Formal Submission Following Response to Submissions Report New High School in Bungendore (SSD-14394209) - Objection to Proposal

Attachment 1 - Comments on Response to Submissions and Amended Design – Bungendore High School – October 2022

Designed	Reviewed	Drawn	Sheet
MW	SCM	MW	B1
Job No.	Status	Date	Scale
5555	SSDA	OCT '21	AS NOTED AT B1
Drawing No.	Revision		
BHS-CE-2002	J

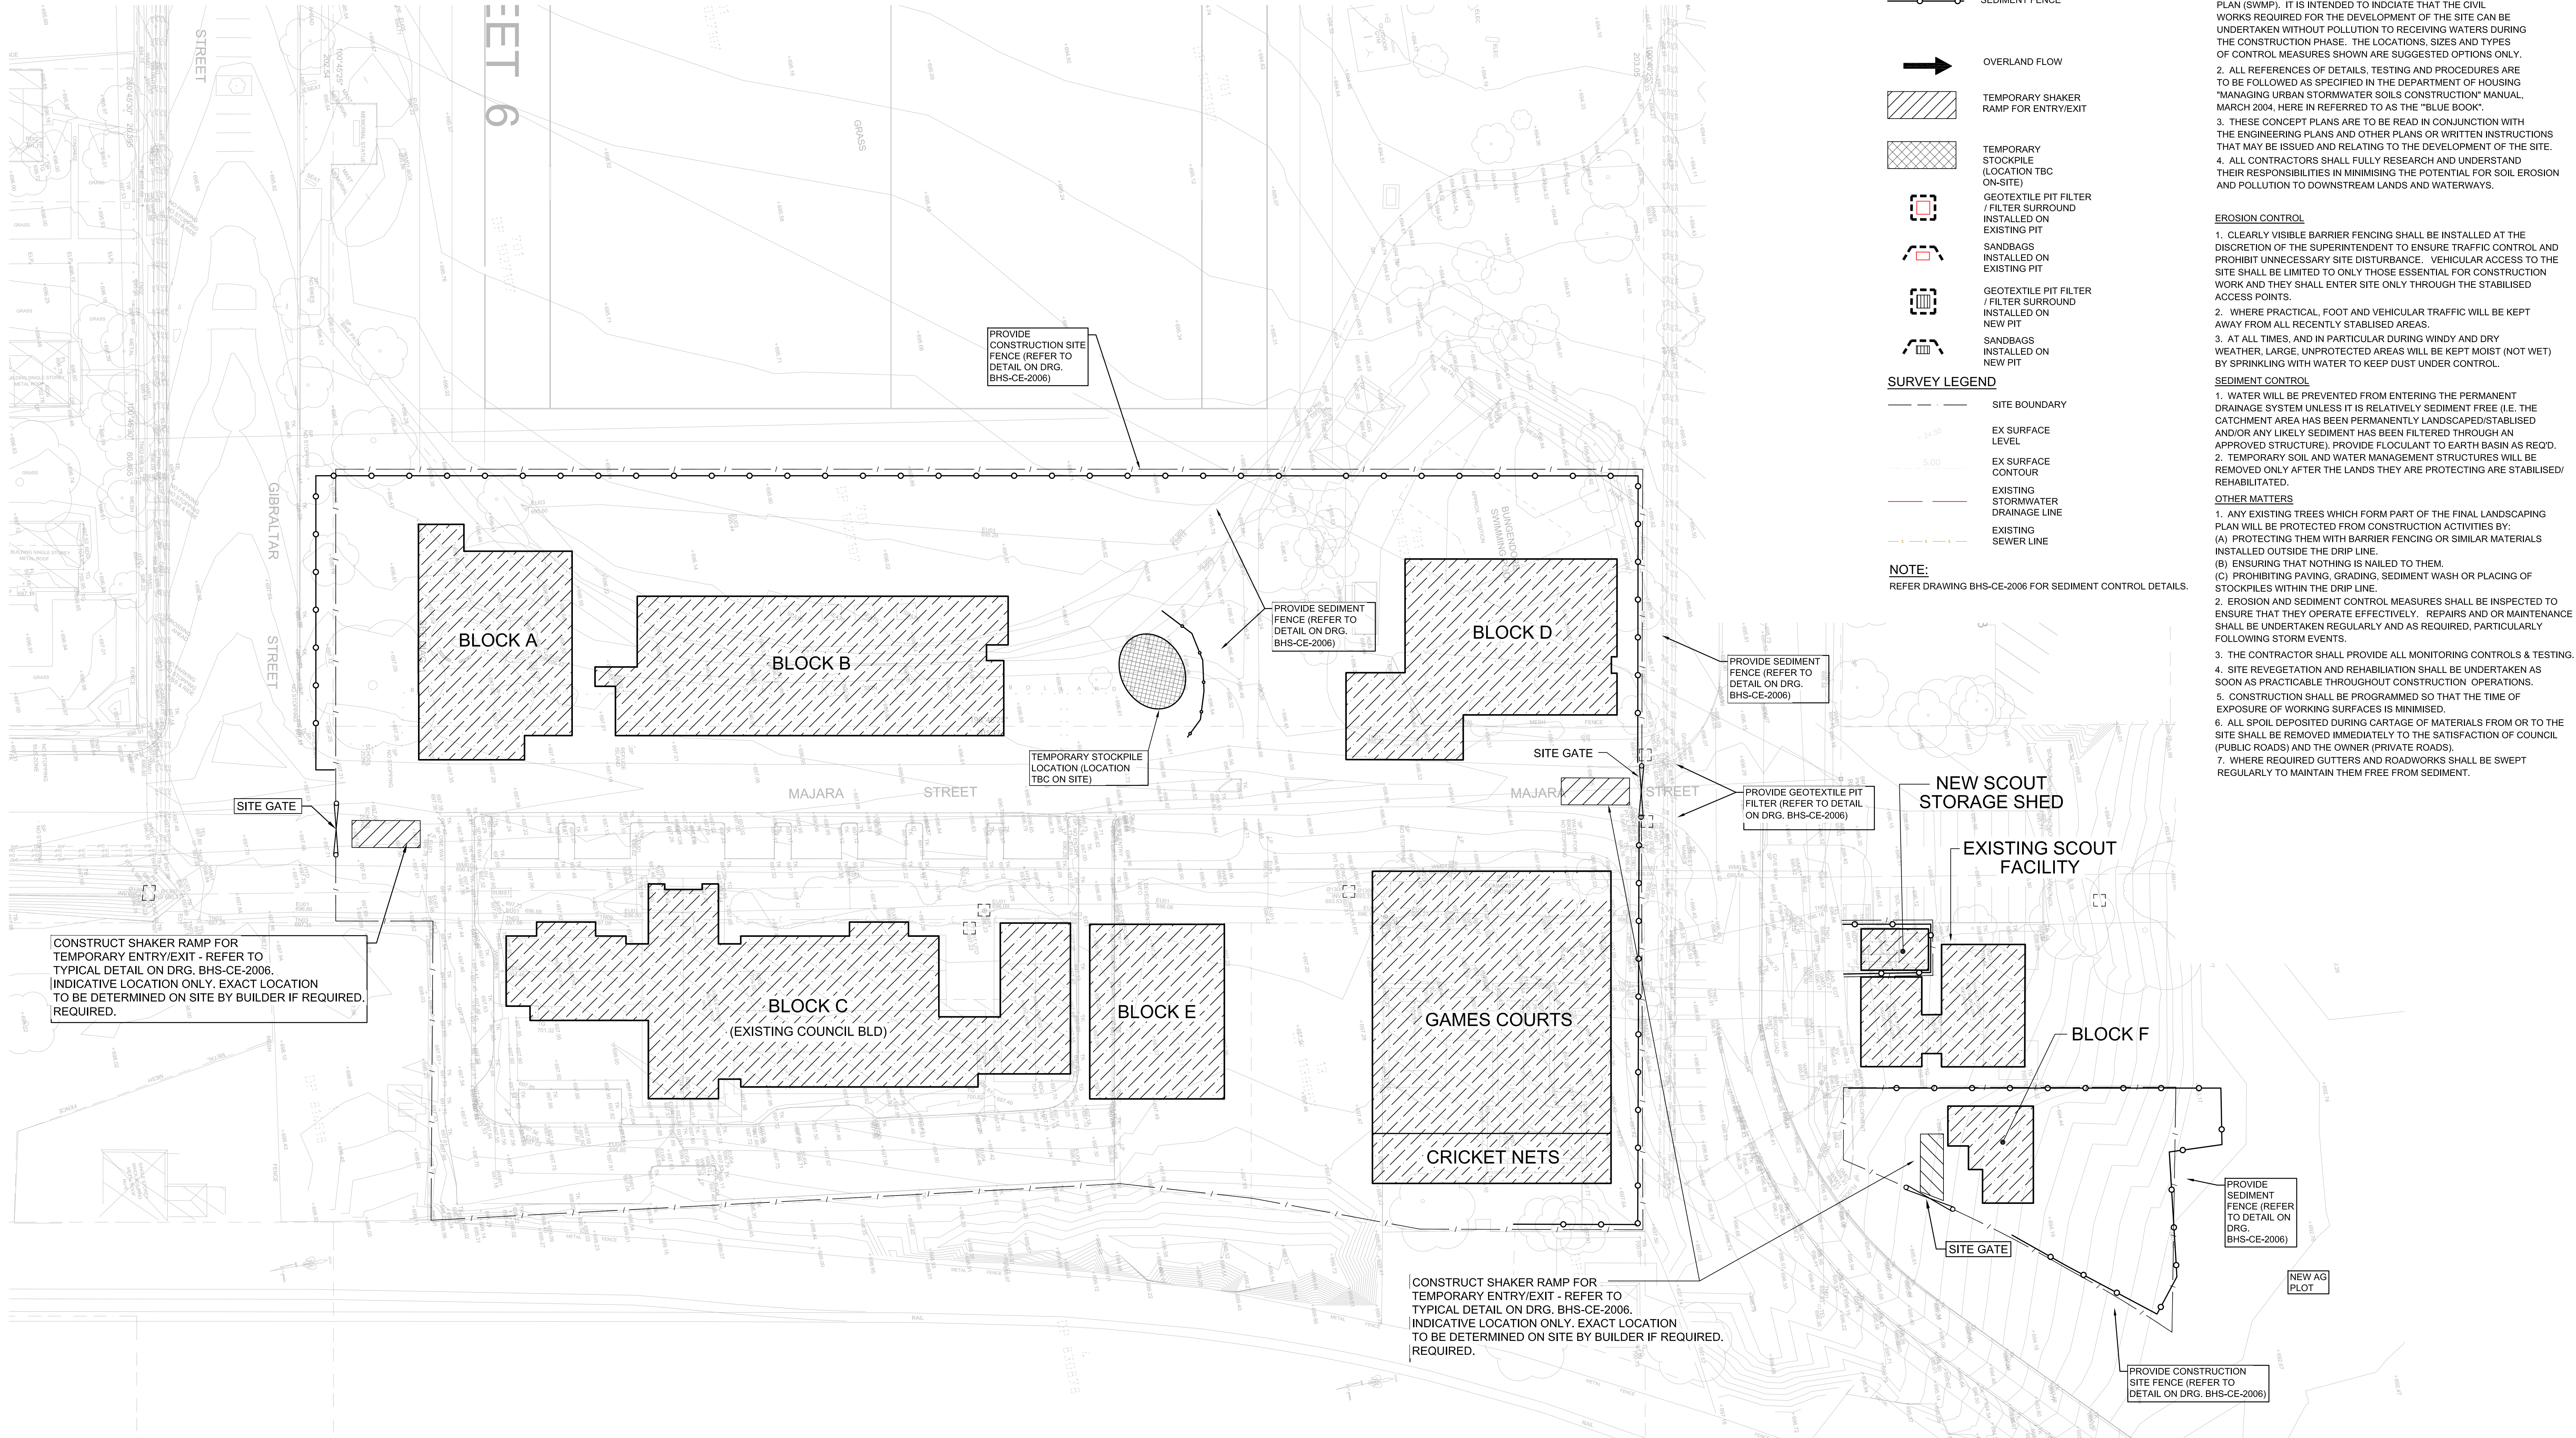
Matter Raised by Council on Original DA	Recommendations from Council's Previous Submission – 29 October 2021	Response from Education	Comment from Council	Recommended Response
<p>4. Erosion and Sediment Control</p>	<p>Council recommends that the consent authority impose conditions requiring the preparation, implementation and maintenance of an erosion and sedimentation plan throughout the construction of the development.</p> <p>(This matter was raised as a request to impose a condition of consent and is not deemed to be an objection).</p>	<p>Appropriate erosion and sediment control measures will be installed prior to commencement of construction works. A condition will be applied requiring preparation of Construction Environmental Management Plan which will provide details of measures to be installed to protect the environment. A preliminary Soil & Water Management Plan (SWMP), in accordance with the "Blue Book" has been prepared and is detailed on M+G drawing No's BHS-CE-2005 & 2006. SWMP containing detailed design of the Sediment Control, Erosion Control and Site Stabilisation practices, including staging of the earthworks and these practices, will be prepared by the earthwork contactor and reviewed and approved by Hindmarsh/M+G prior to civil works commencing. This plan will include monitoring provisions that will allow the SWMP to be changed/modified during the works to ensure that the required Water Quality Objective are achieved during the construction stage.</p>	<p>Council is satisfied that the applicant understands the need for compliance with this requirement.</p> <p>However, there appear to be some inconsistencies in the earthworks cut/fill plan. It appears to show fill on top of an existing building. It is recommended that a long section through the school avenue to demonstrate overland flow of the broader stormwater network be provided.</p>	<p>Council reiterates its request for the consent authority to impose conditions requiring the preparation, implementation and maintenance of an erosion and sedimentation plan throughout the construction of the development.</p> <p>Further the applicant should be requested to address inconsistencies in the earthworks cut/fill plan.</p>
